December 23, 2019

Kiowa Engineering
c/o Chris Castelli

RE: North Bay – Construction Plan Set

North Bay at Lake Woodmoor
Redbridge Point -- Plan and Profile
Shoreditch Heights -- Plan and Profile
El Paso County, Colorado

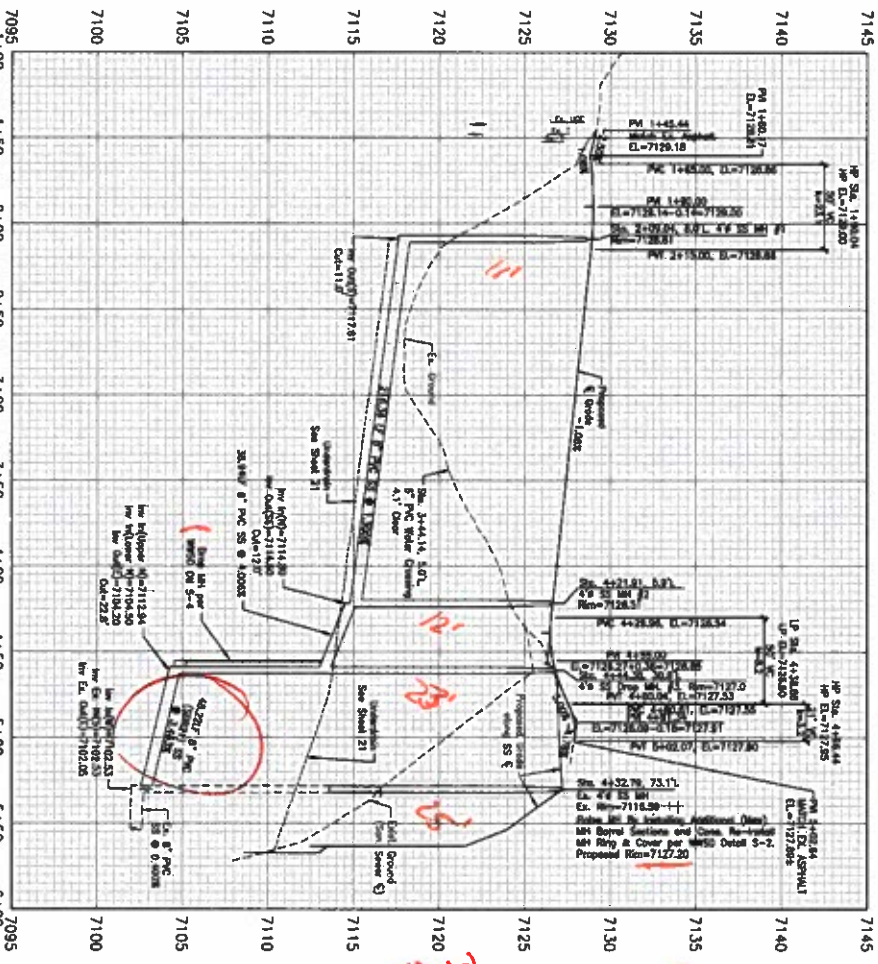
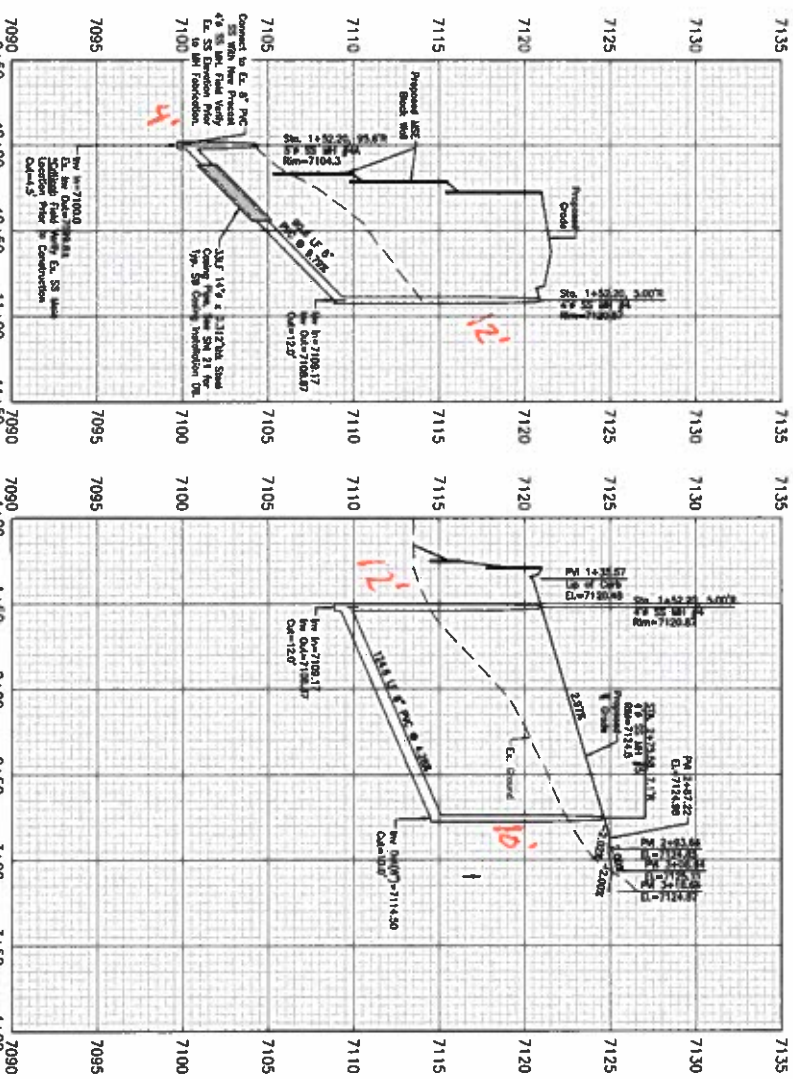
1. On the Redbridge Point plan, please label the description and width of what looks to be an easement for sanitary sewer.
2. On the Redbridge Point profile, the sanitary sewer pipe deeper than 15 feet should be Ductile Iron Pipe or HDPE Pipe.
3. On the Shoreditch Heights plan, please label utility easements.

Utility Service Plan

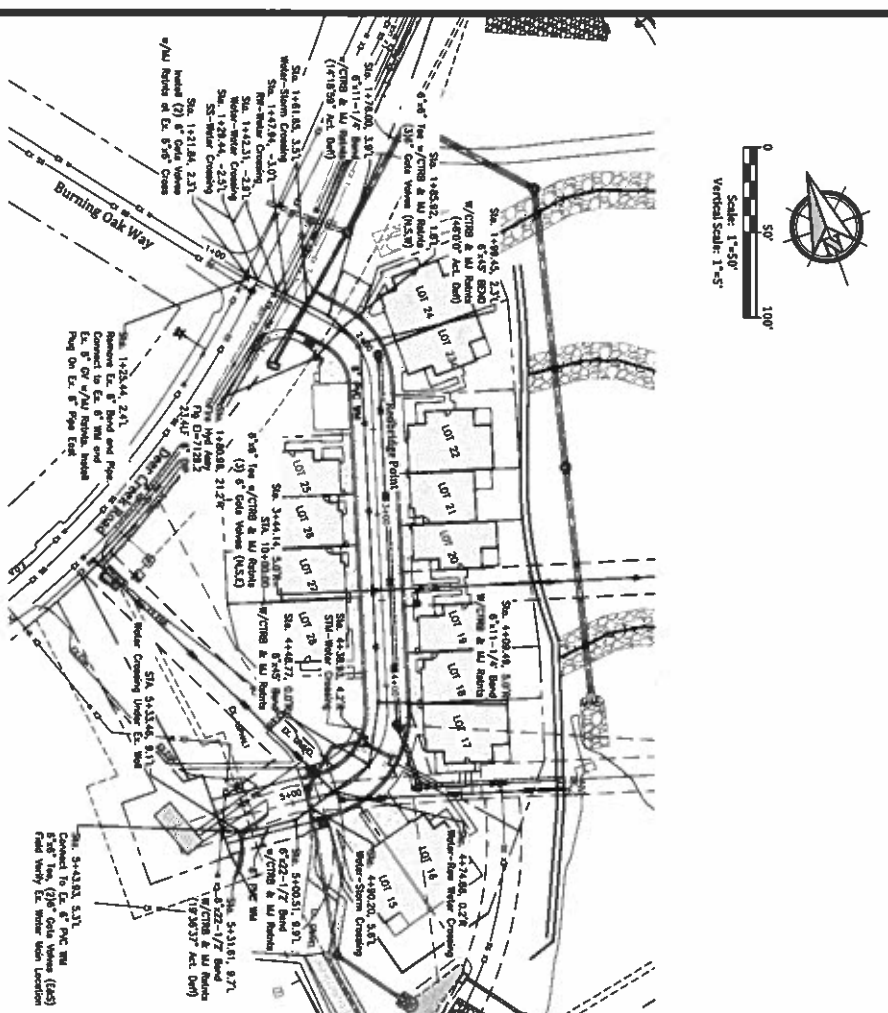
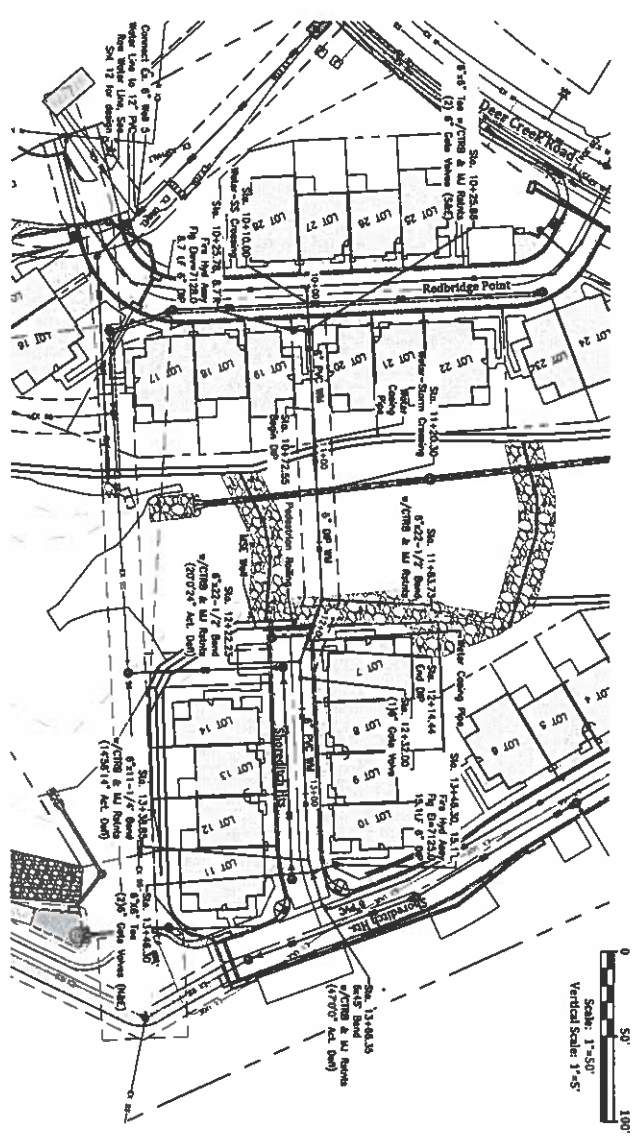
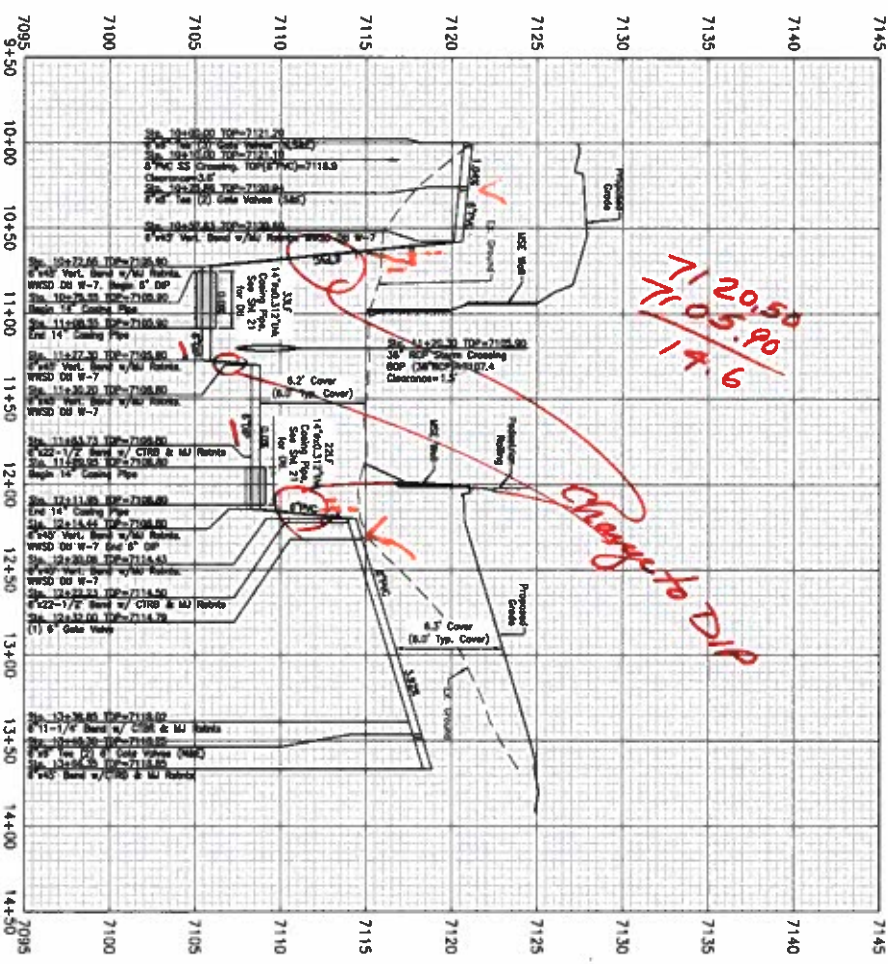
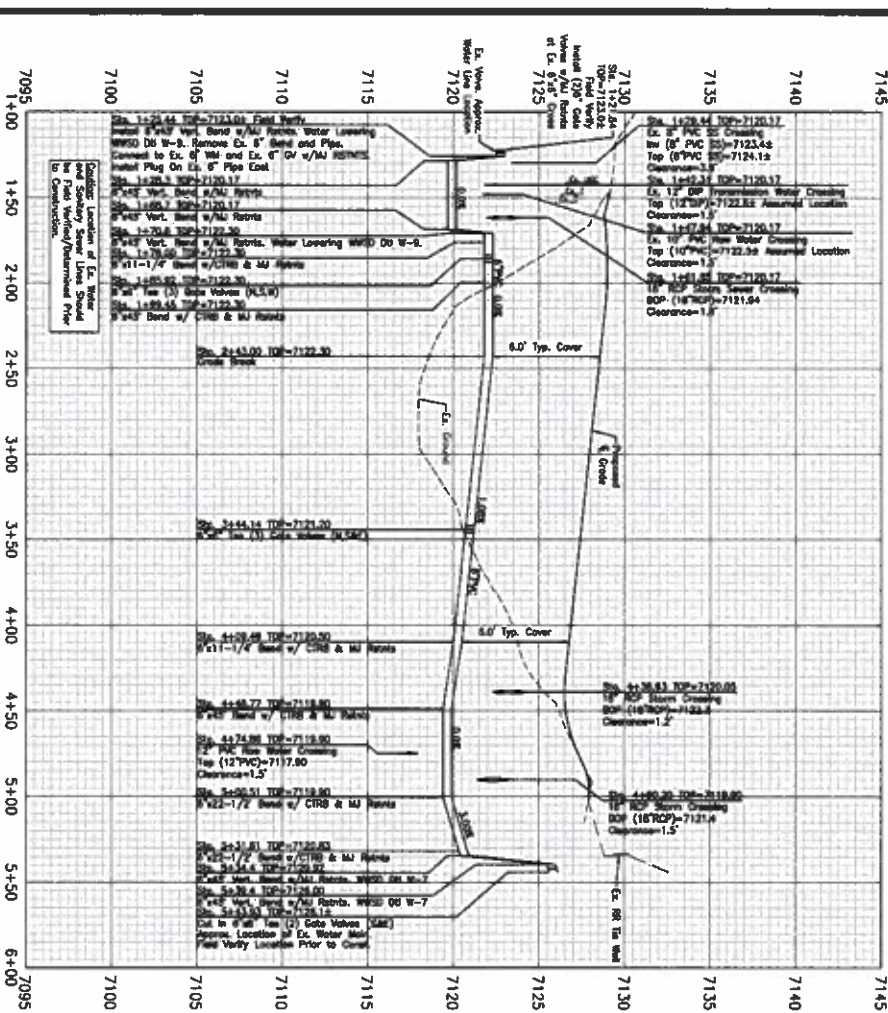
1. Please label and note the width of all easements.

2. Please ensure that no gap exists in the easement containing the sanitary sewer and raw water lines, between lots 16 and 17.
